Bayside Council

2nd September 2019

RE: Qantas Flight Training Centre (SSD-10154) – Response to Submissions

Council staff have reviewed the RtS prepared by the applicant in response to the issues raised in Council's submission dated 11th July 2019 and provide the following feedback:

#### Appendix 4 Proposed Site Plan & Tree Protection Plan

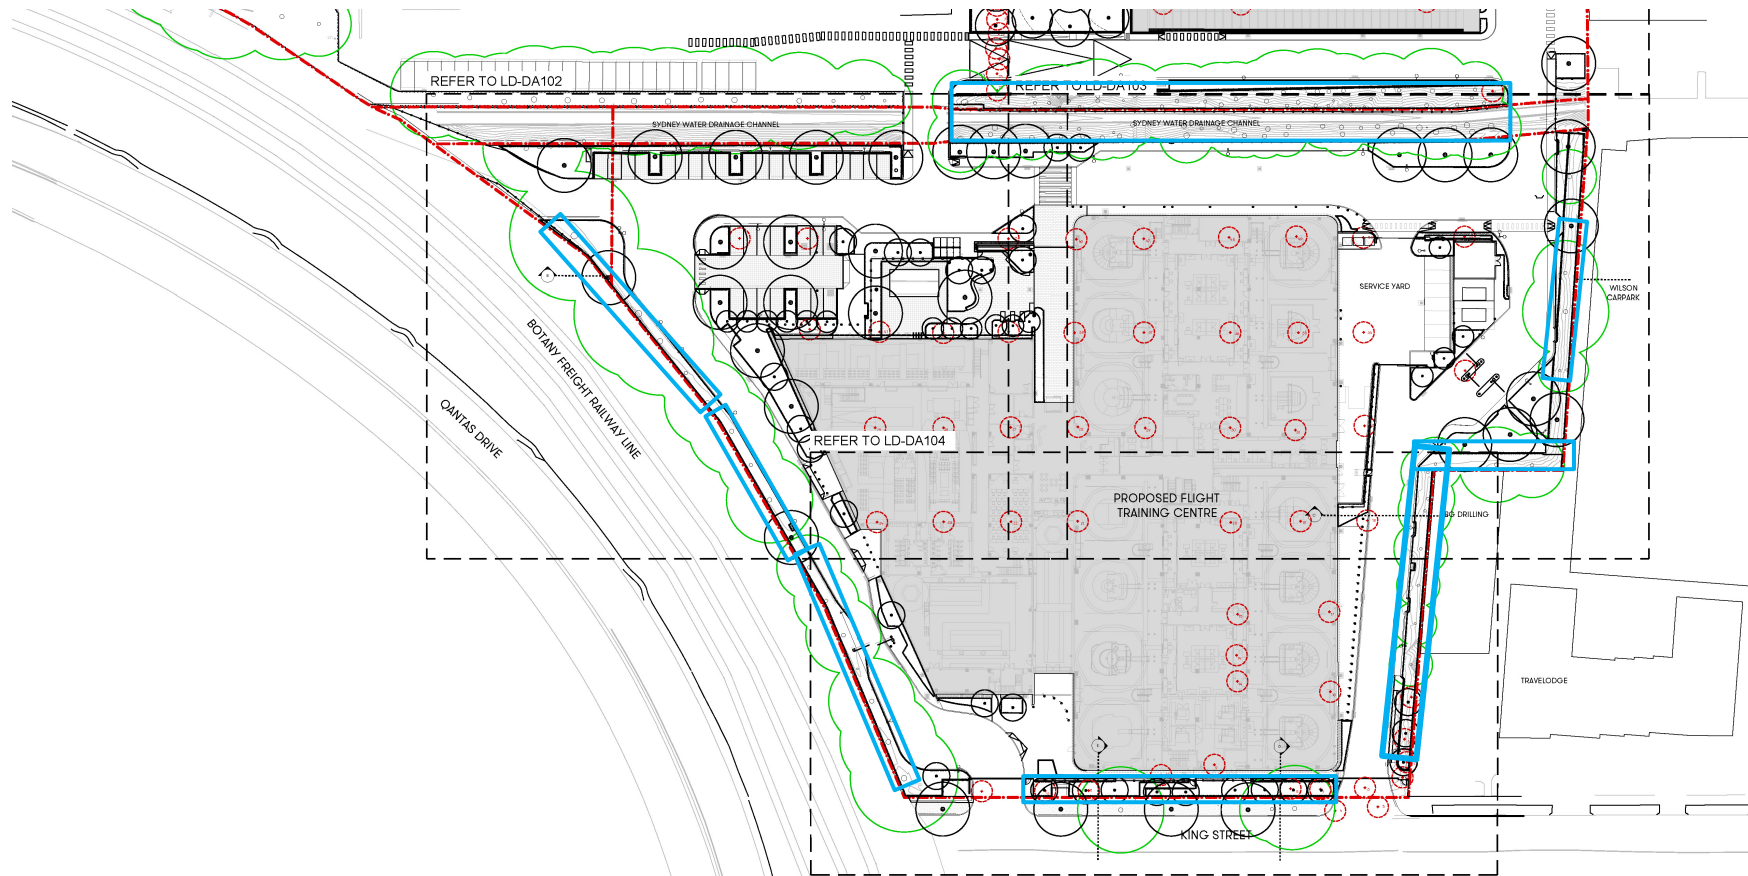
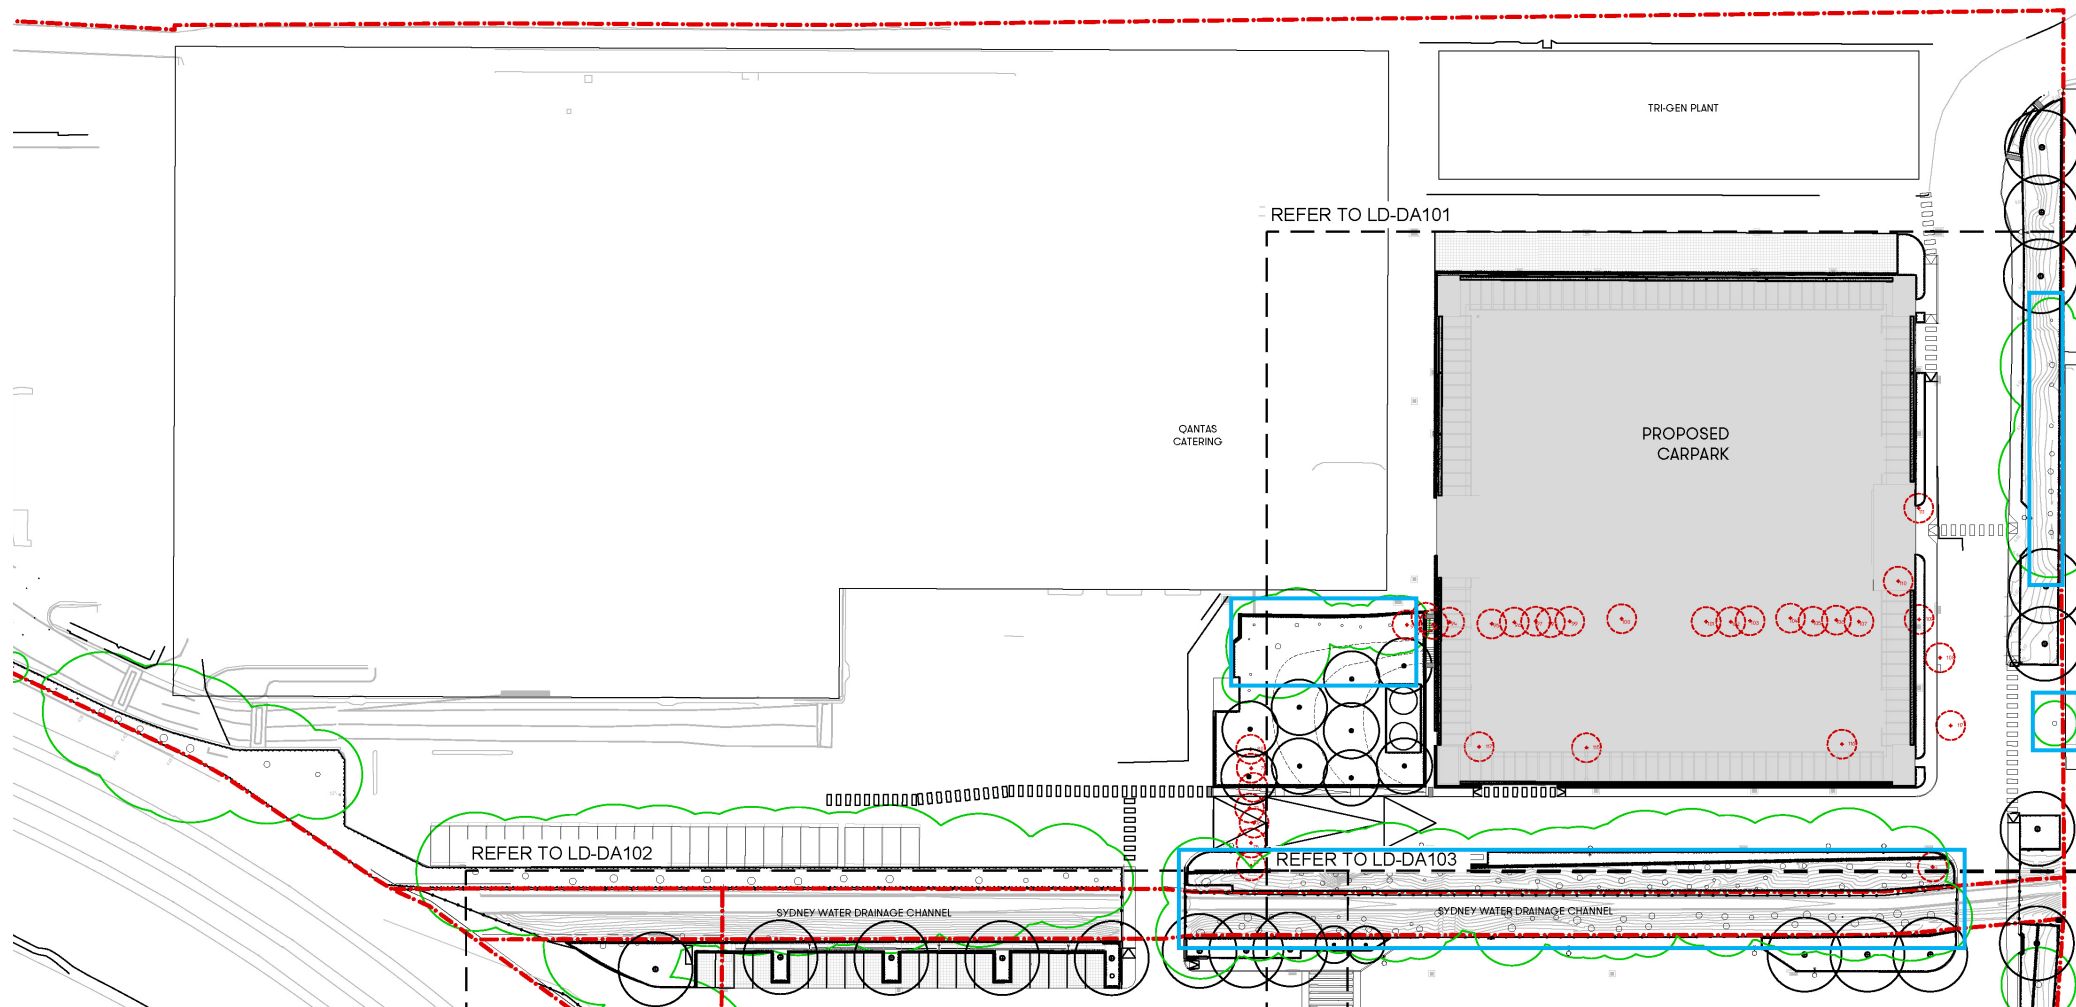
Note: Maintenance does not include trimming or pruning of trees under any circumstances.
 - 4) A suitably qualified project arborist (AQF level 5 or greater) is to be engaged to implement tree protection measures before and during construction to all existing trees to be retained within the site and along the verge strip of King Street in accordance with the management plan contained in the Arborist report prepared by The Ents Tree Consultancy, dated 30th July 2019. Evidence of engagement of a project arborist is to be submitted to, and approved by, Council.

LANDSCAPE GENERAL ARRANGEMENT 3
 Date 20180199 [Drawn] LD-DA103 [Rev] 1

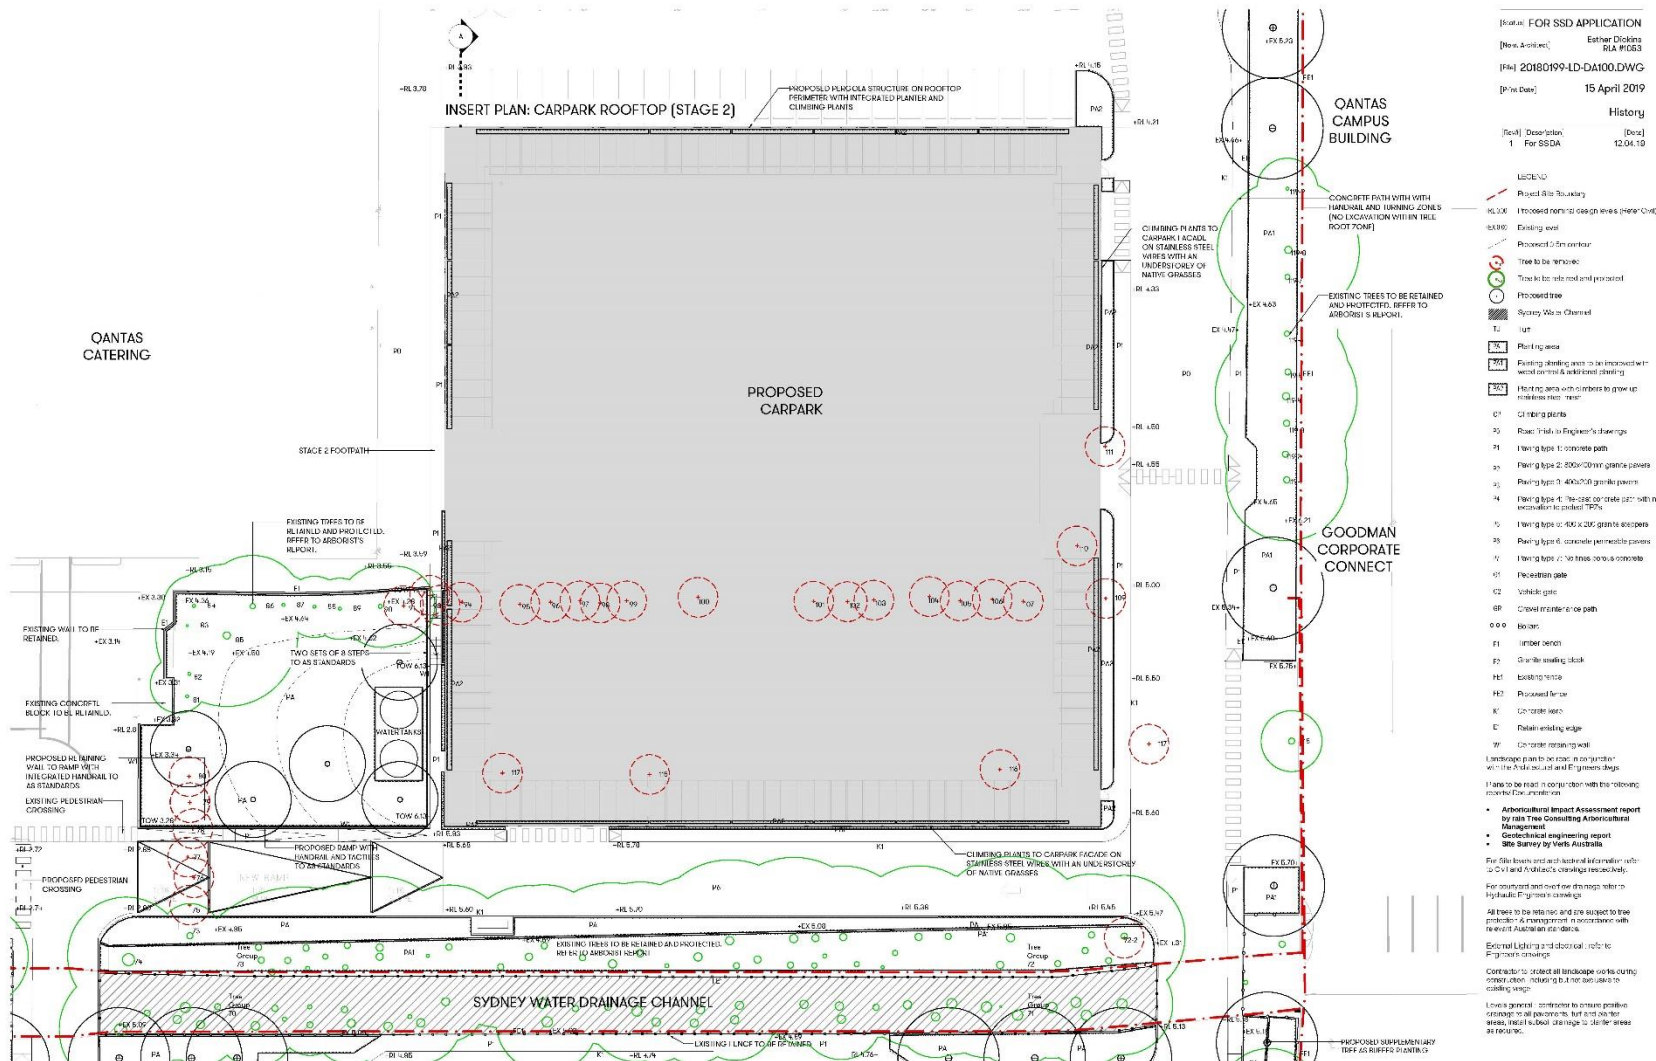
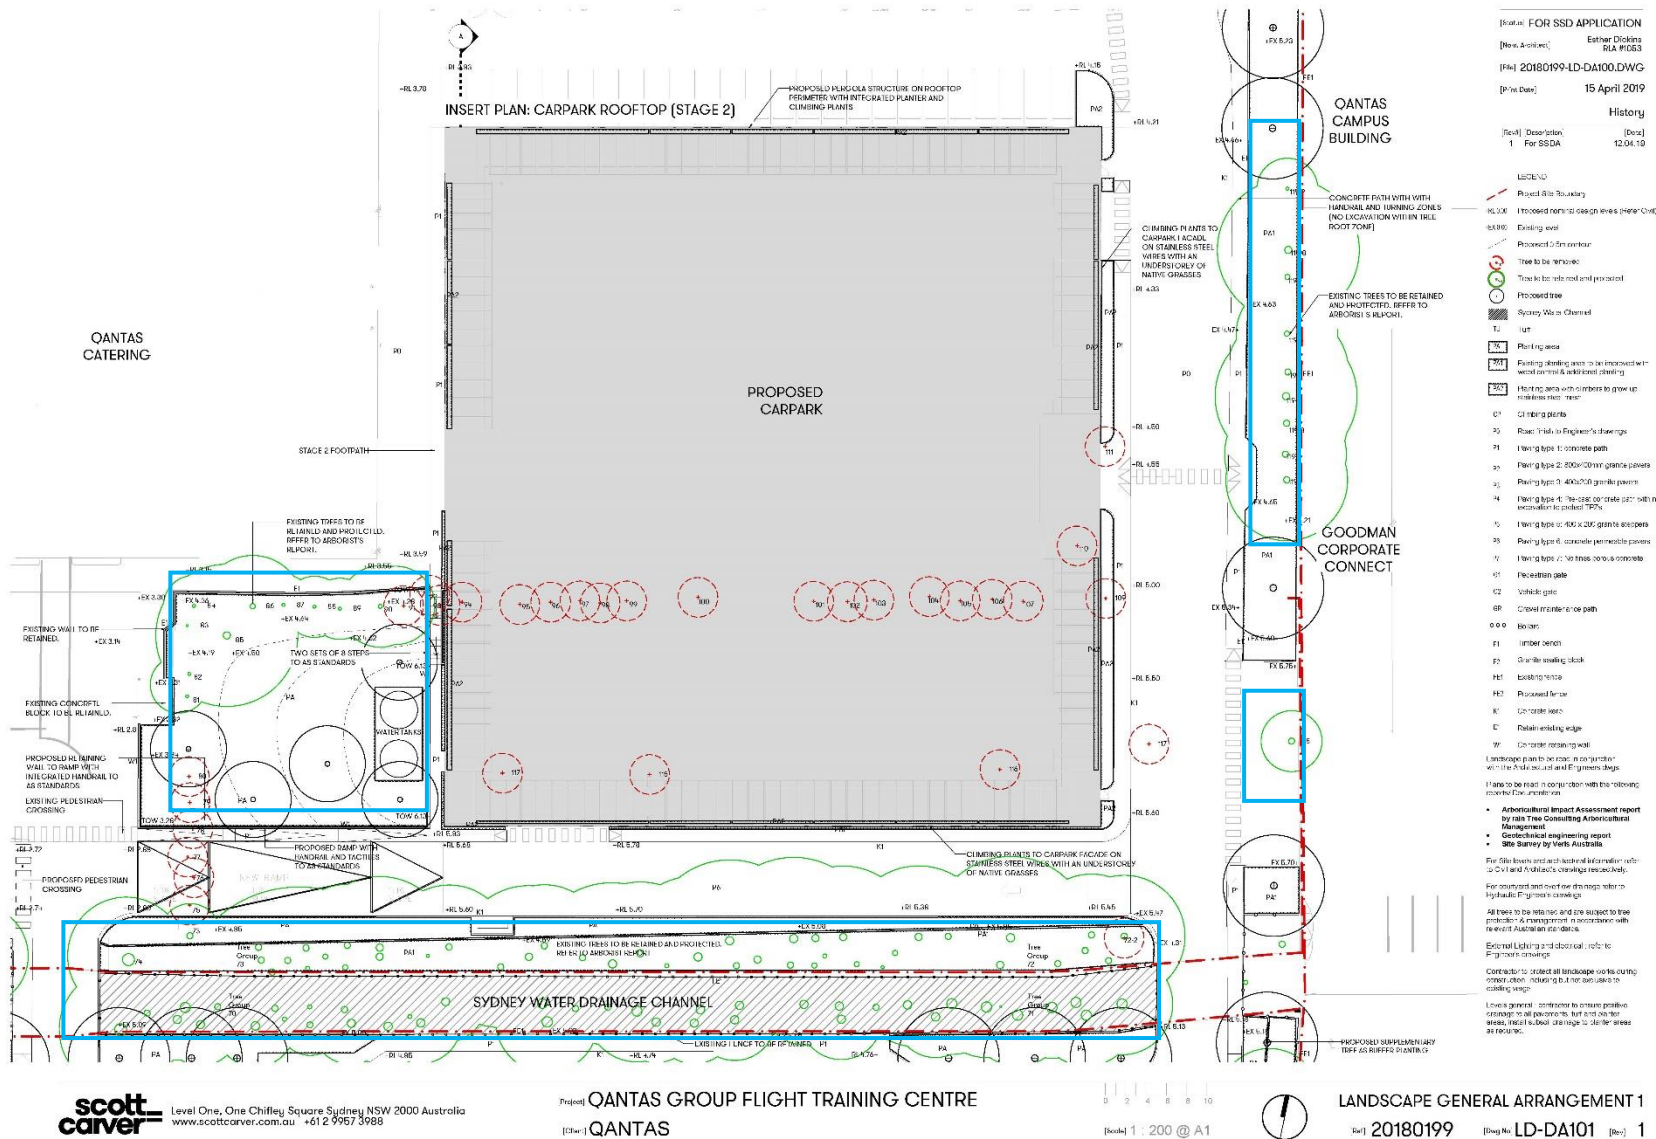
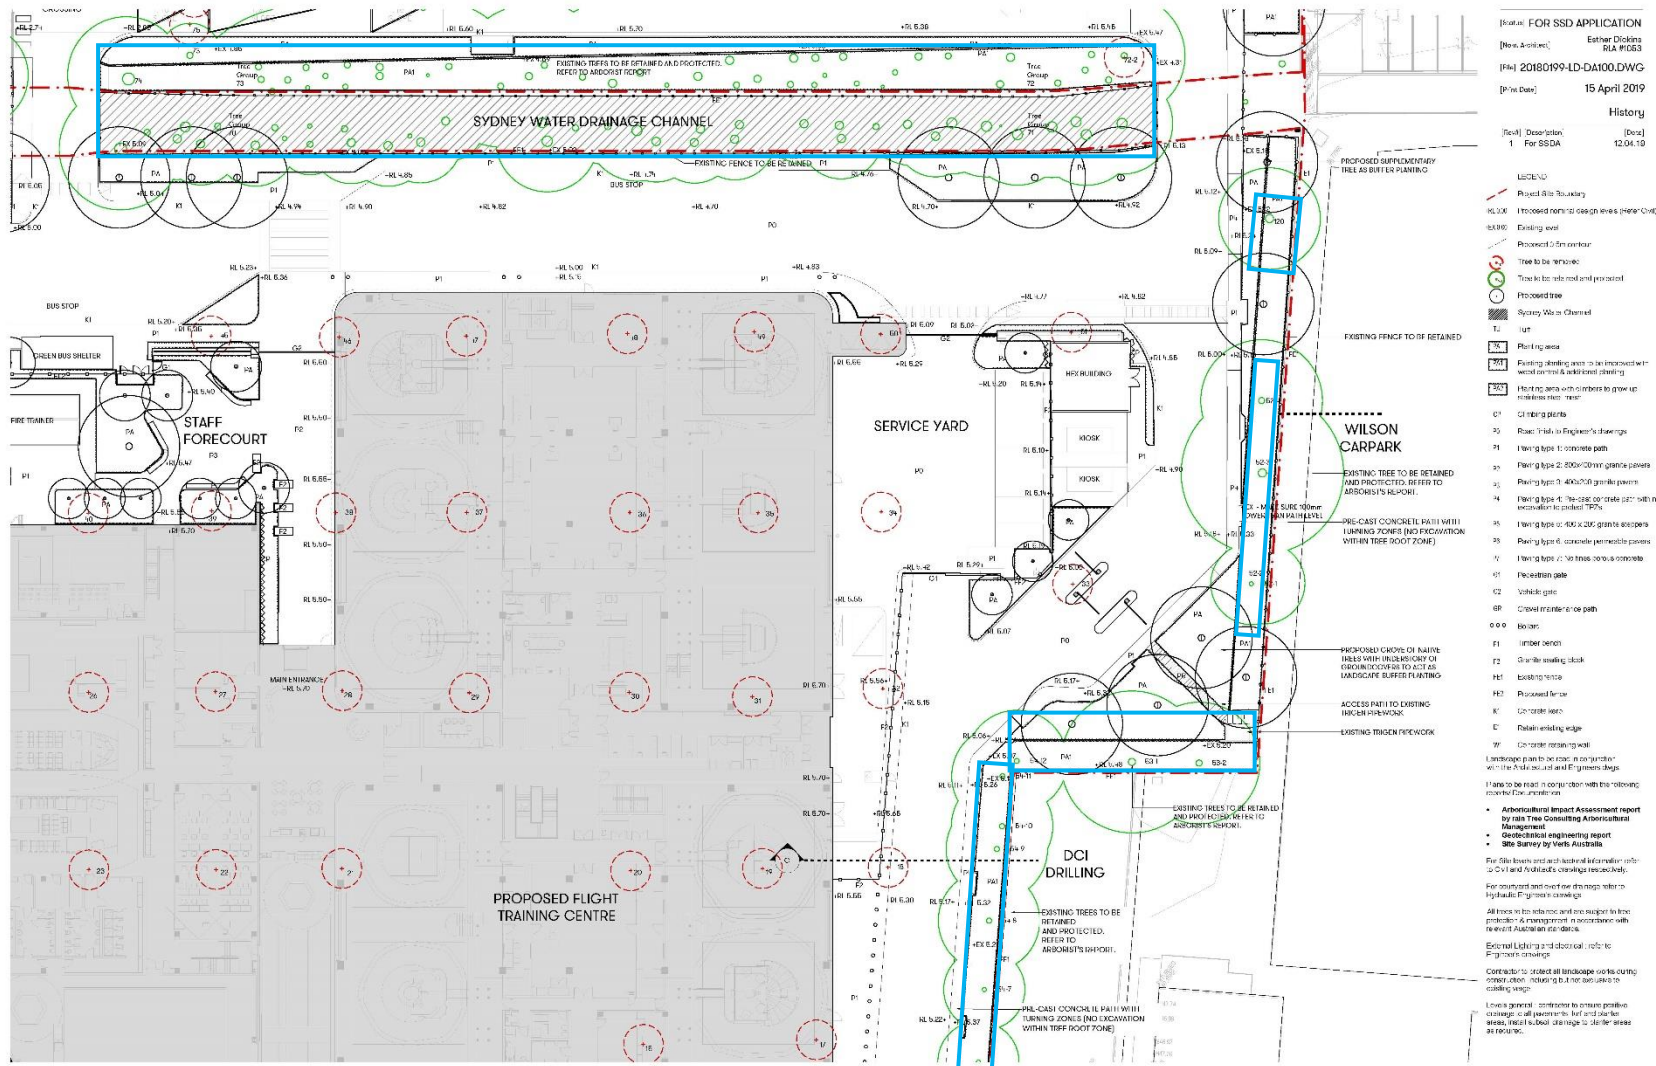
The amendments made to the proposal are supported subject to the inclusion of the following conditions being included in the determination:

- 1) The Final Landscape Plan shall be generally in accordance with the Landscape Plan prepared by Scott Carver, revision 2, dated 31st July 2019 and comprise detailed landscape construction documentation (plans and specifications) to be submitted to, and approved by Bayside Council's Landscape Architect prior to the issue of the Construction Certificate. The landscape documentation shall include, but not be limited to:

- a) Planting plan at 1:100 showing all plant locations/ groupings and plant centres/ species. There is to be a dense layered planting scheme consisting of trees, shrubs and groundcovers in all of these areas.

- b) Construction Details of the proposed 21 façade planters that work as green walls and the bus shelter green roof, including details of planting; and a 12 months maintenance schedule of these elements.

- c) Elevated planter box sectional details and drainage details. All planter box depths and dimensions shall be in accordance with Council's DCP and capable of supporting medium and large trees.
